The Woodland Trust

Planning Application - 24/00539/F

Land East of Stratfield Brake and West of Oxford Parkway Station (known as 'The Triangle')
proposal for a stadium for Oxford United Football Club (OUFC).

Drawing  
**TREE REMOVAL & ARBORICULTURAL IMPACT  
 ASSESSMENT PLAN**

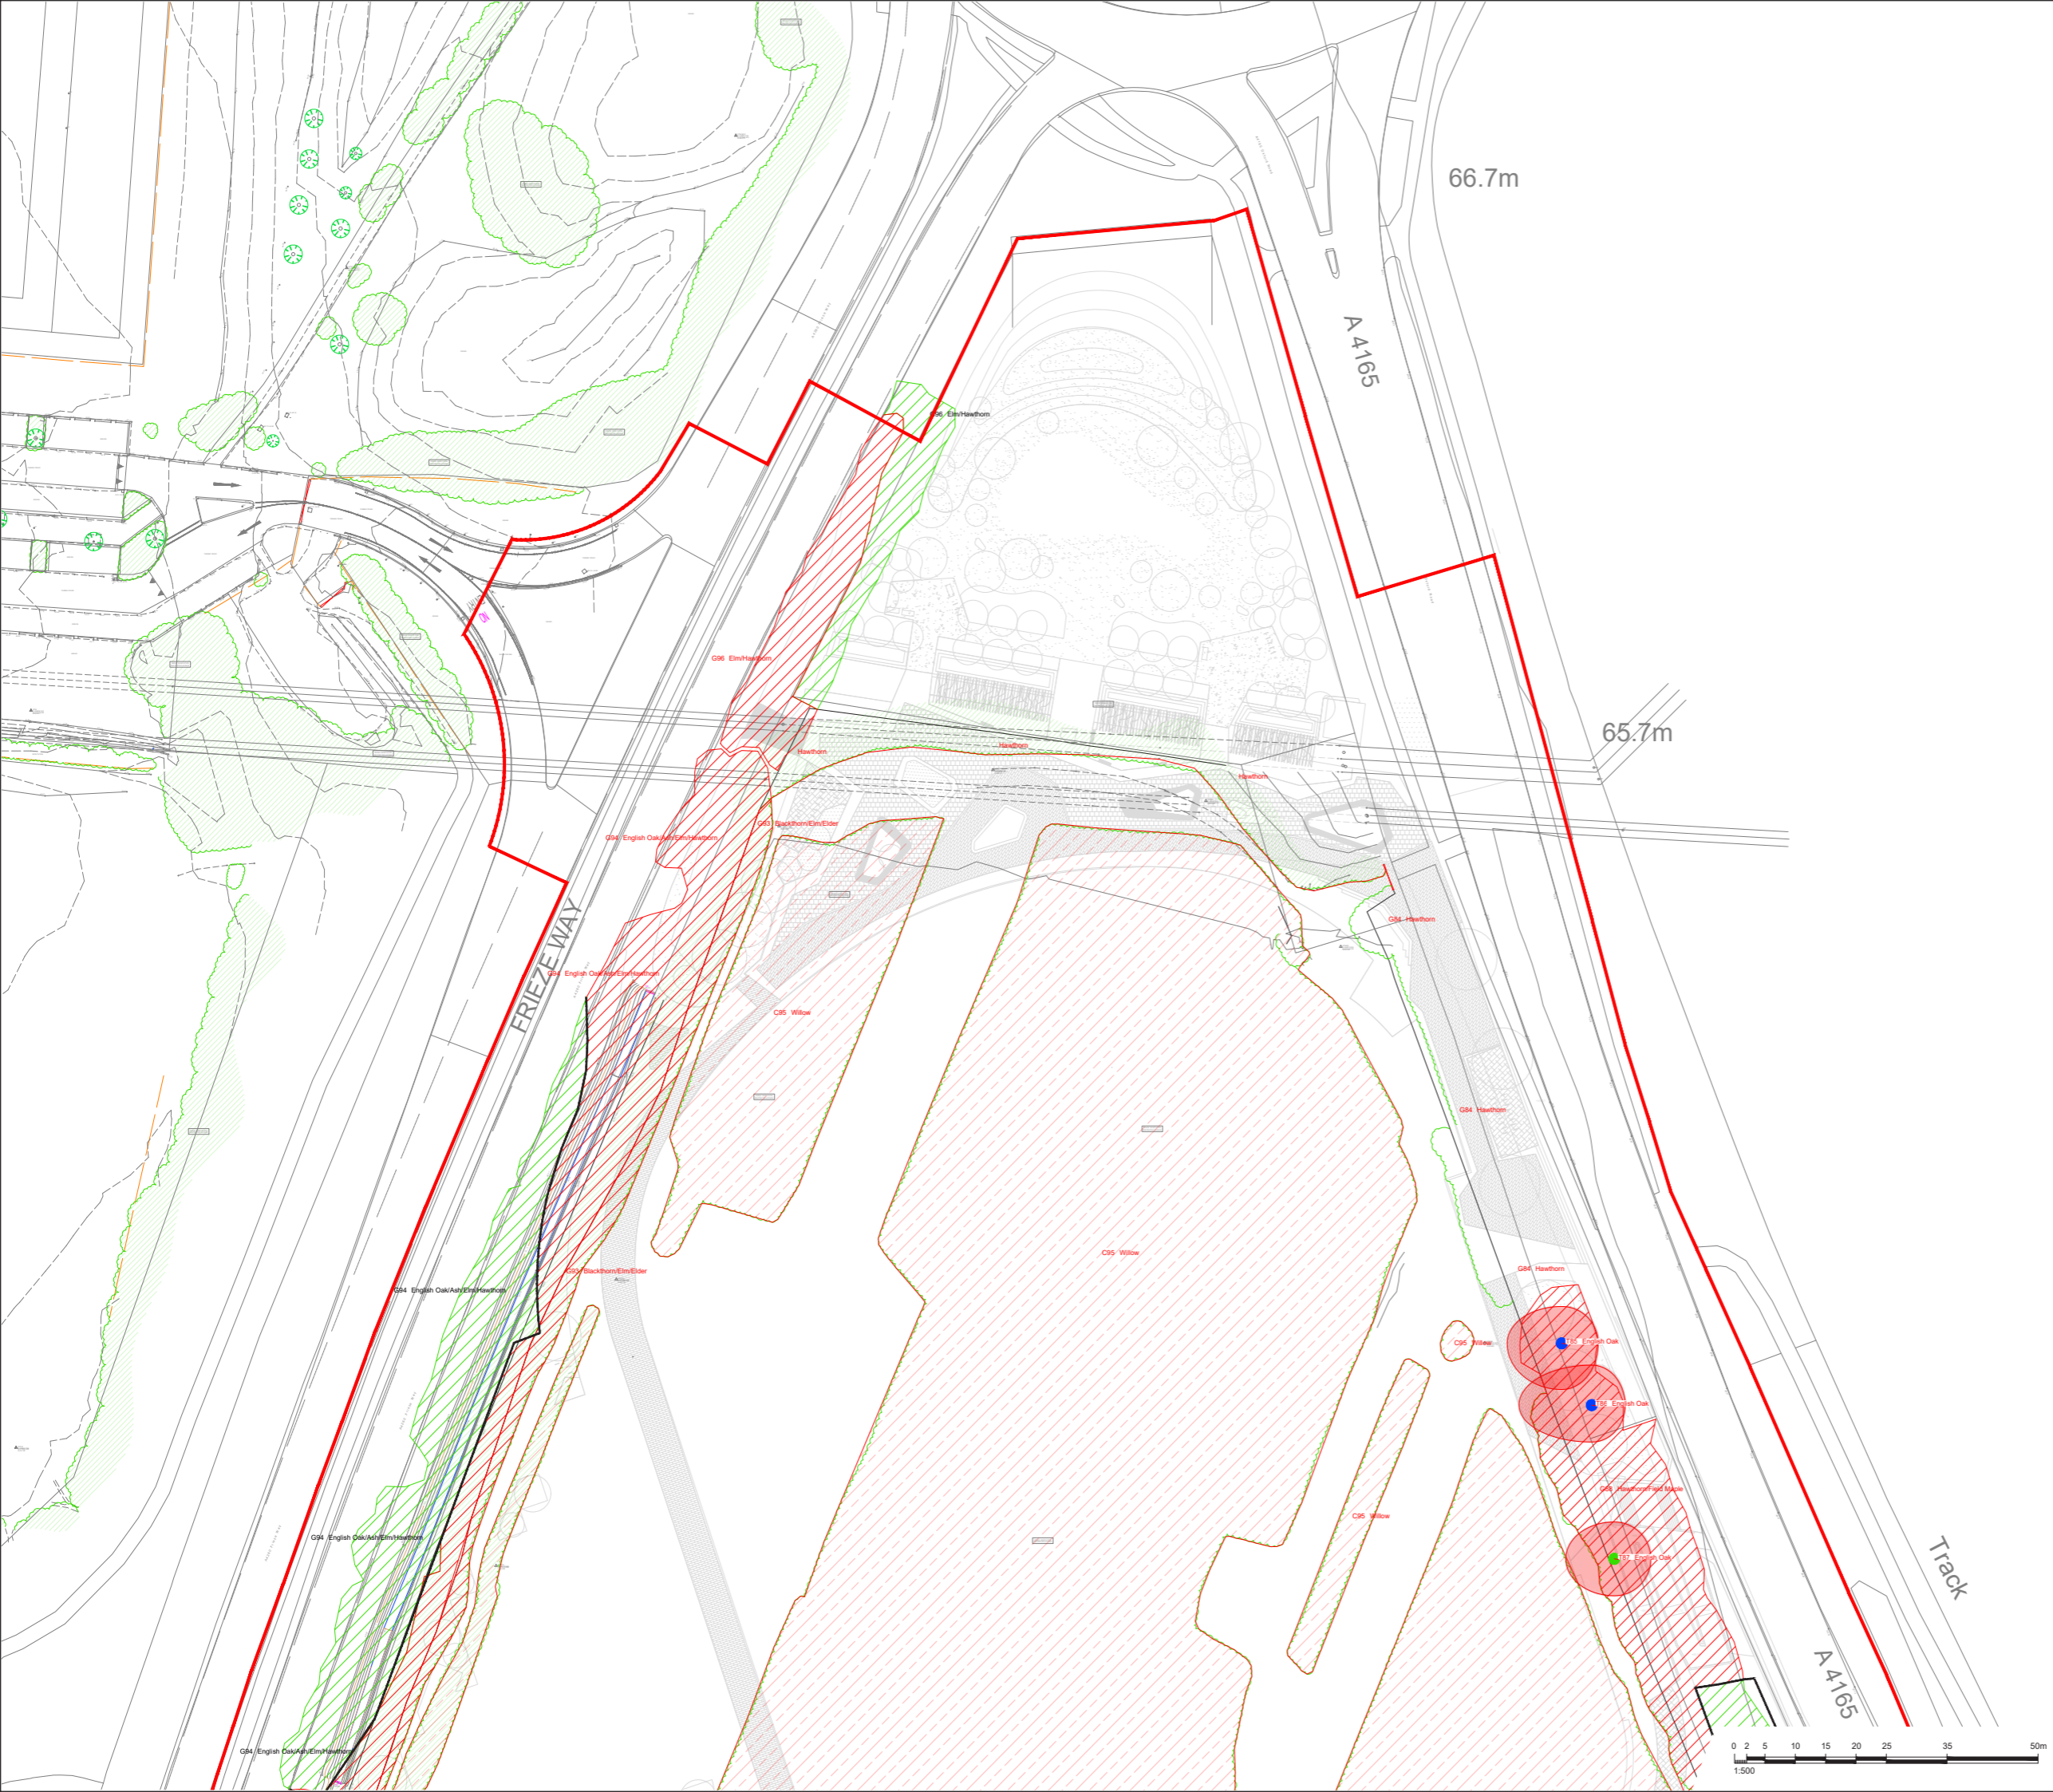
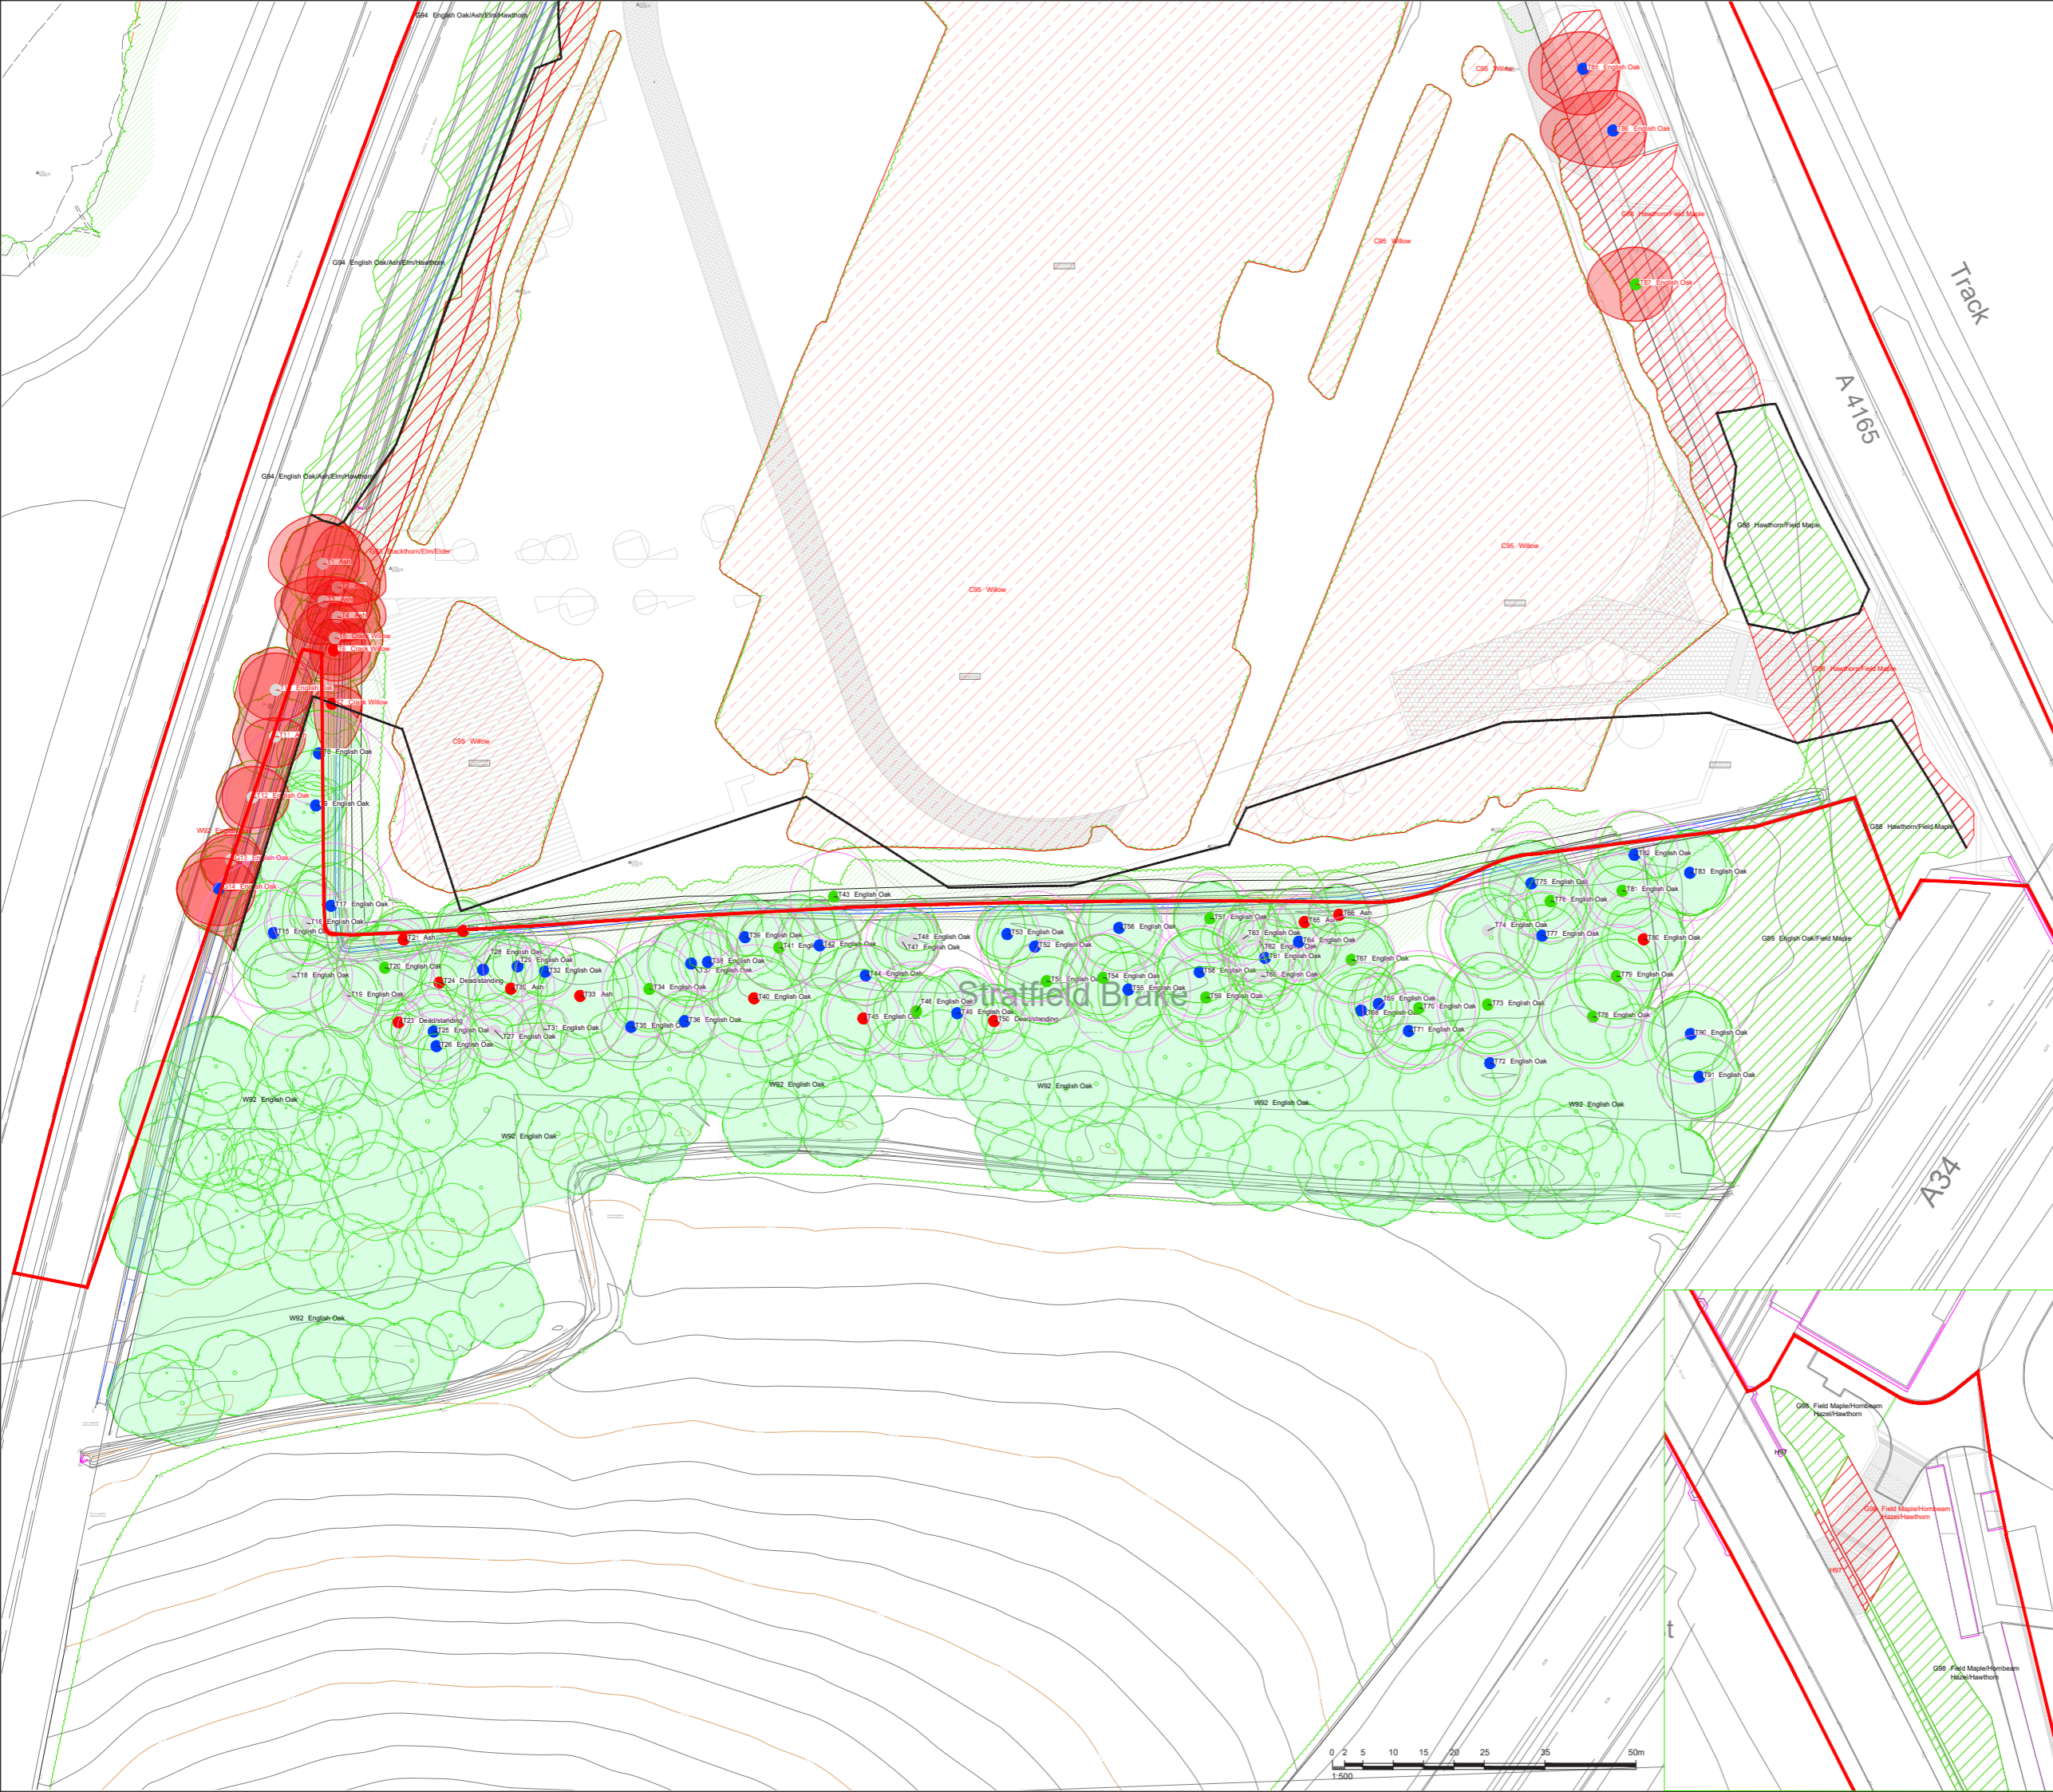
We are concerned to see that the plans propose the removal of some established trees, including two TPO oak trees on the eastern boundary of the site. We ask that the **retention of these important trees** be required and secured by planning condition.

Figure 8.1: Proposed Catchment Areas

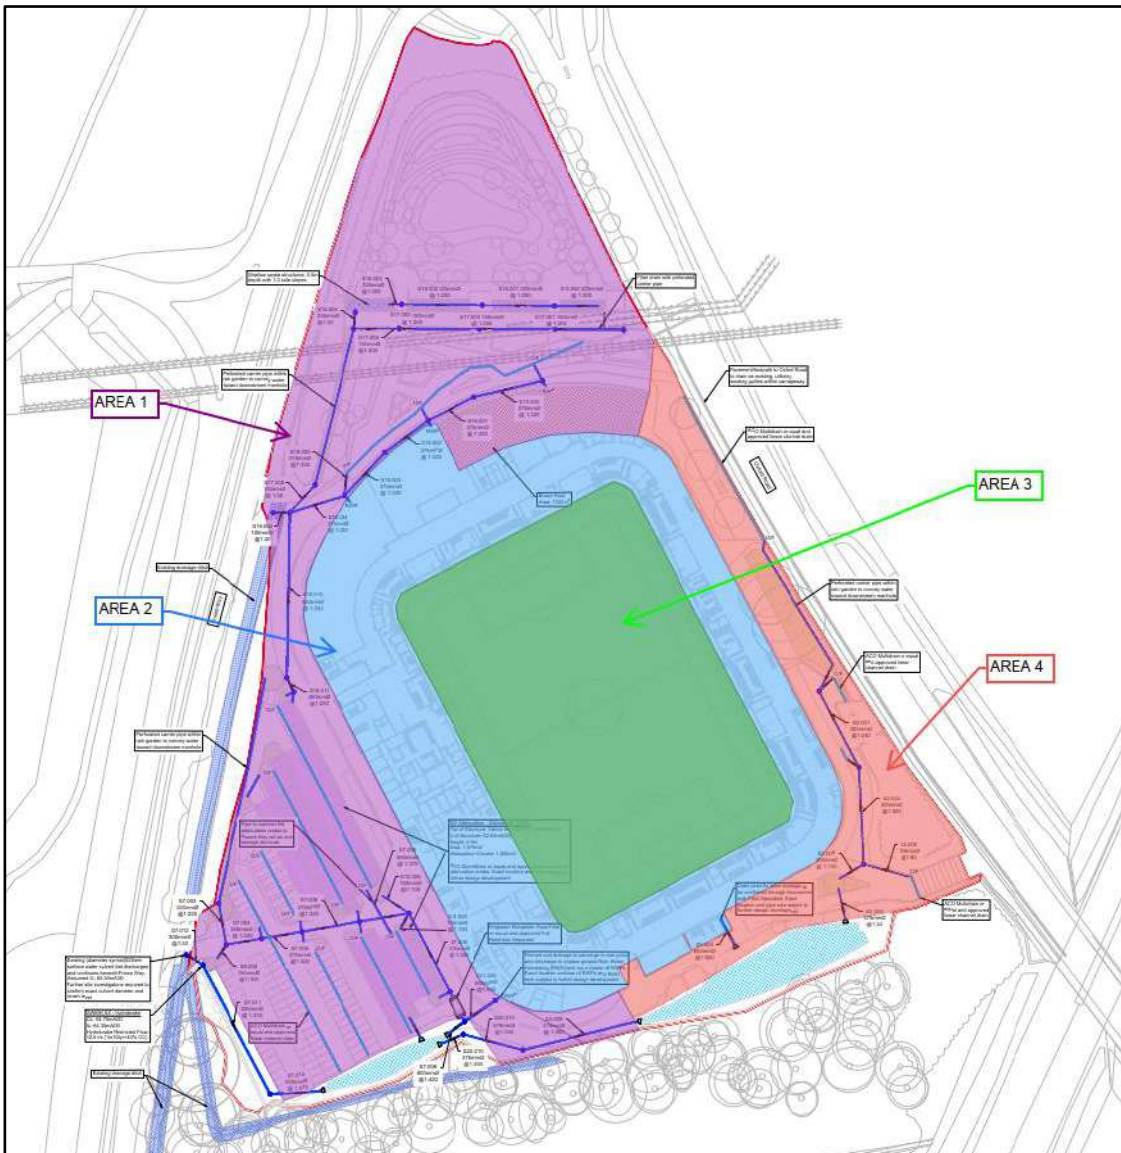
We note that the application refers to a drainage strategy, providing onsite attenuation in the form of ponds and geo cellular crates. Other SuDS features like rain gardens, swales and filter drains will also provide some attenuation. **We ask that this provision be of a scale and capacity sufficient to protect Stratfield Brake from additional run-off and that this is secured by planning condition.**
